Comments for Planning Application 21/00097/APP

Application Number: 21/00097/APP

Address: Treasures Drayton Beauchamp Buckinghamshire HP22 5LS

Proposal: Installation of Steibel Eltron WPF S 13kW ground source heat pump

# Treasures, Drayton Beauchamp

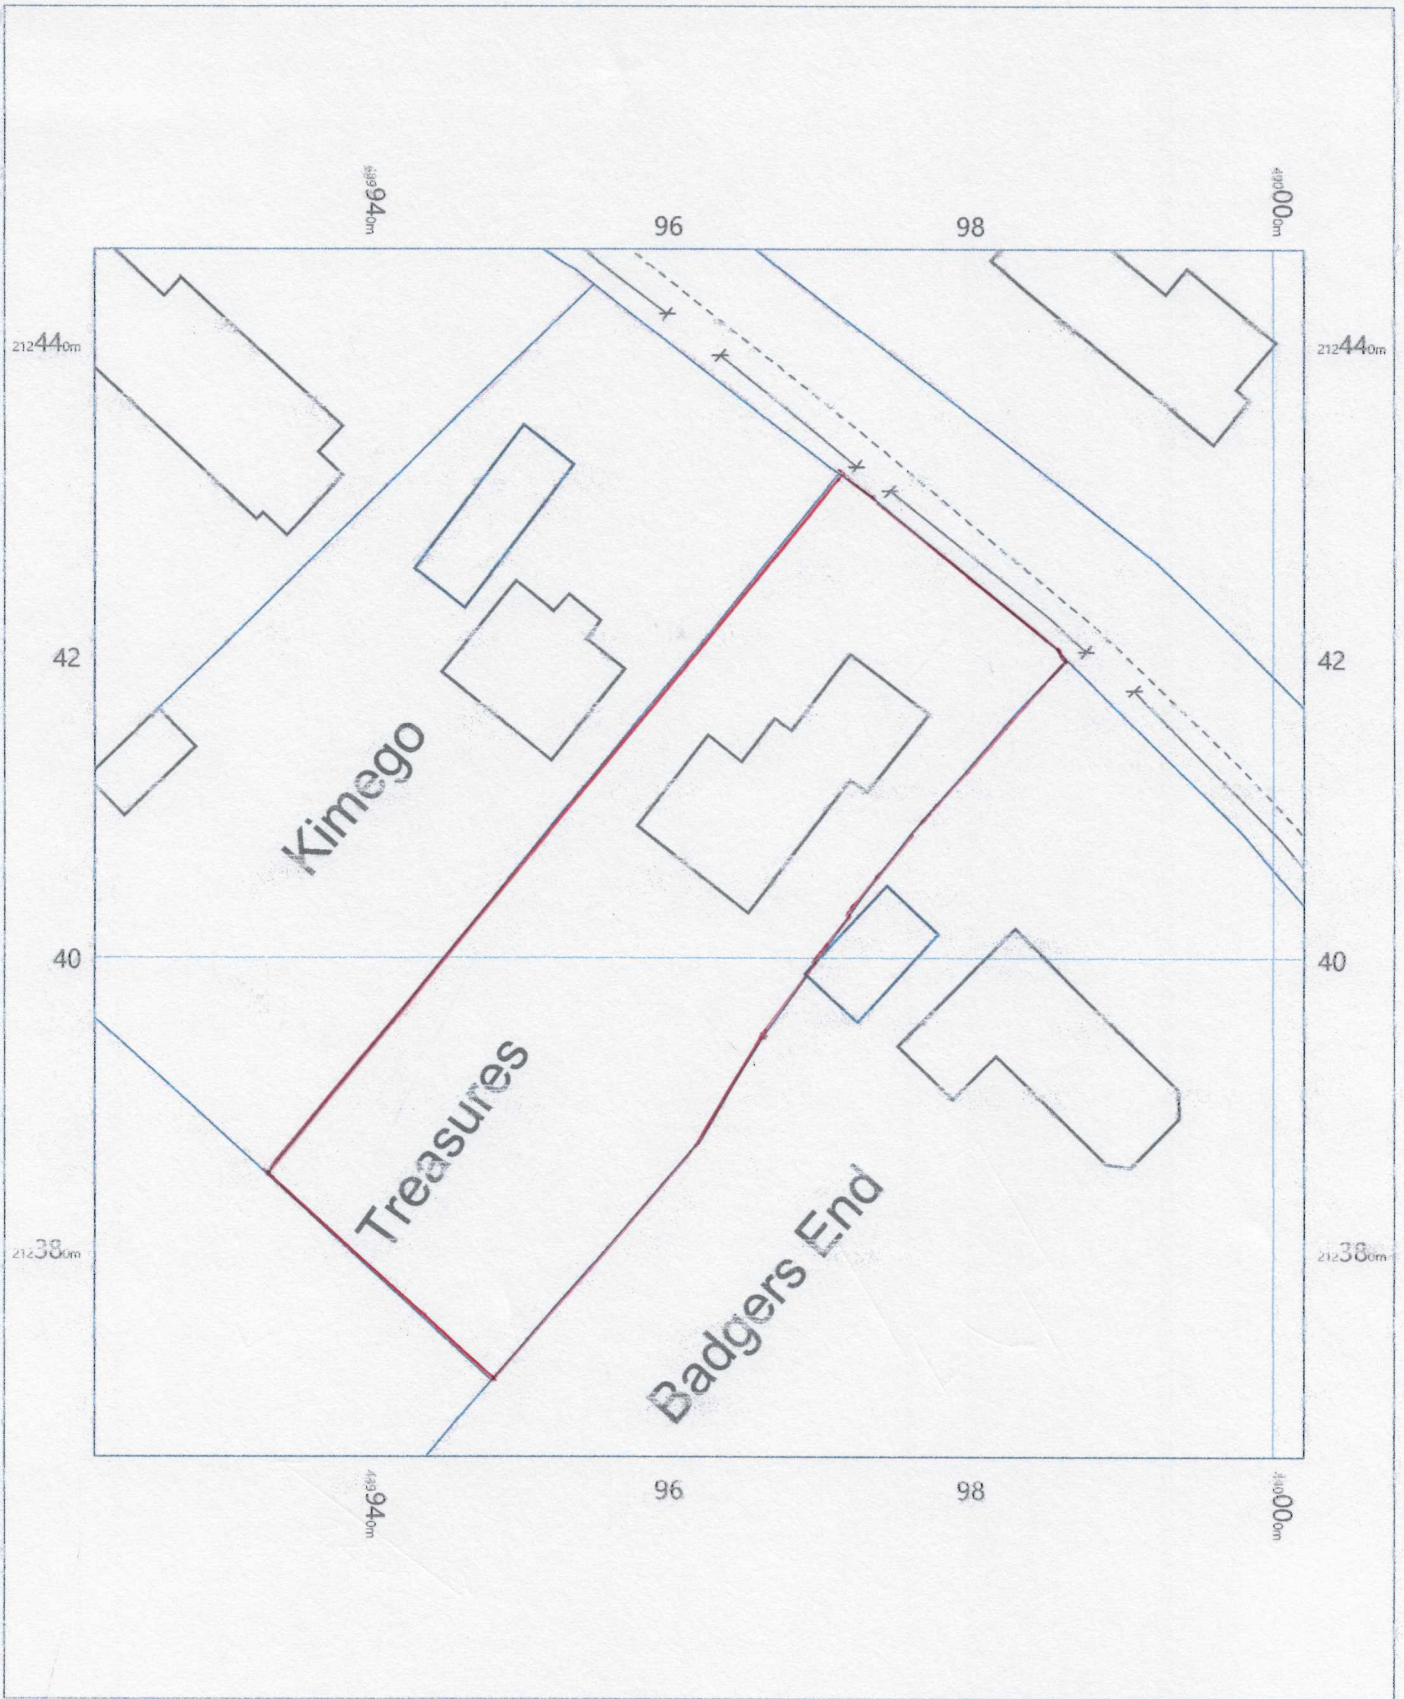
This application refers only to a ground source heat pump, shown by the plans as being enclosed in a wooden structure abutting a free standing garage to the front of the property. The garage is shown in a location that significantly differs from that approved on the 16th June 2020, under planning reference 20/01114/APP, yet it is not referred to in this application although the new garage location is outlined on the plans. Our concern is that the approval of this application could result in the relocated garage being approved by default. We are concerned about the new location of the garage as it has been moved approximately 4 metres closer to the front boundary leaving only 2 metres of garden frontage to the highway as opposed to the approved plan that showed a garden frontage with a depth of 6 metres. This frontage strip contains mature trees that are an important feature in the street scene and the change may already have damaged roots to these trees.

LEAN-TO
SHED FOR
GRIFT EQUIPMENT/
SERVICES,
FORMED IN
HORIZONTAL
WEATHERBOARDING
TO MATCH GARAGE.

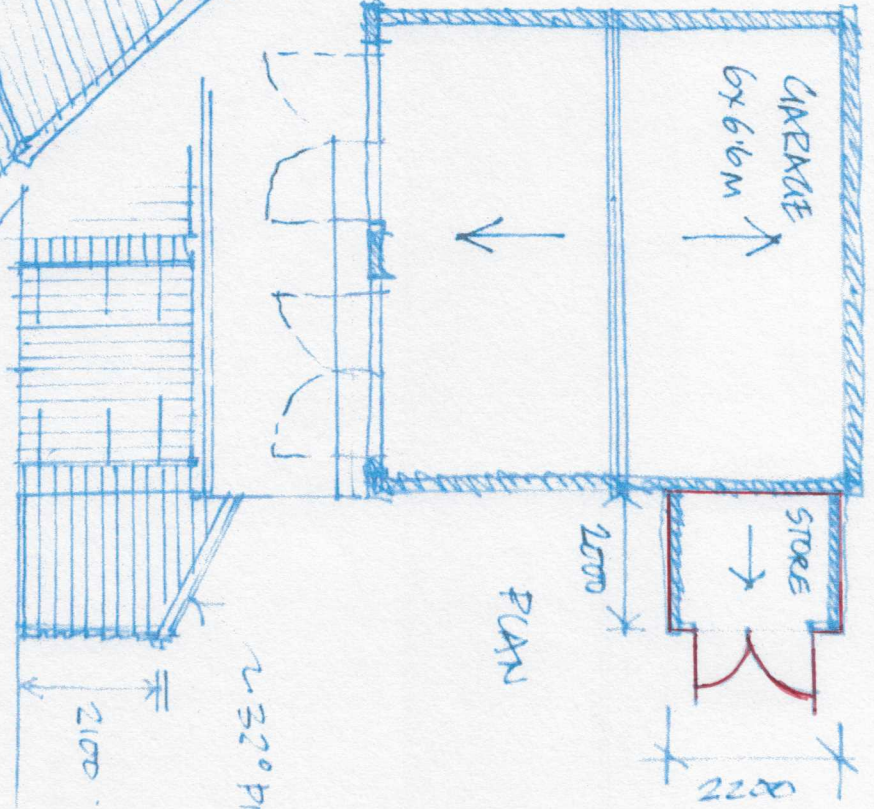
Representations were made by the Parish Meeting on the adverse effect that the proposals set out in application 20/01114 would have, being unduly prominent and harmful to the visual amenity and character of the adjoining conservation area. We believe that the latest changes to the garage location worsen that impact and are concerned that the construction of the garage is continuing despite it being in the wrong location. We would add that were the garage to be located in the position shown on the approved plans (20/01114) then the heat pump and enclosure would need to move.
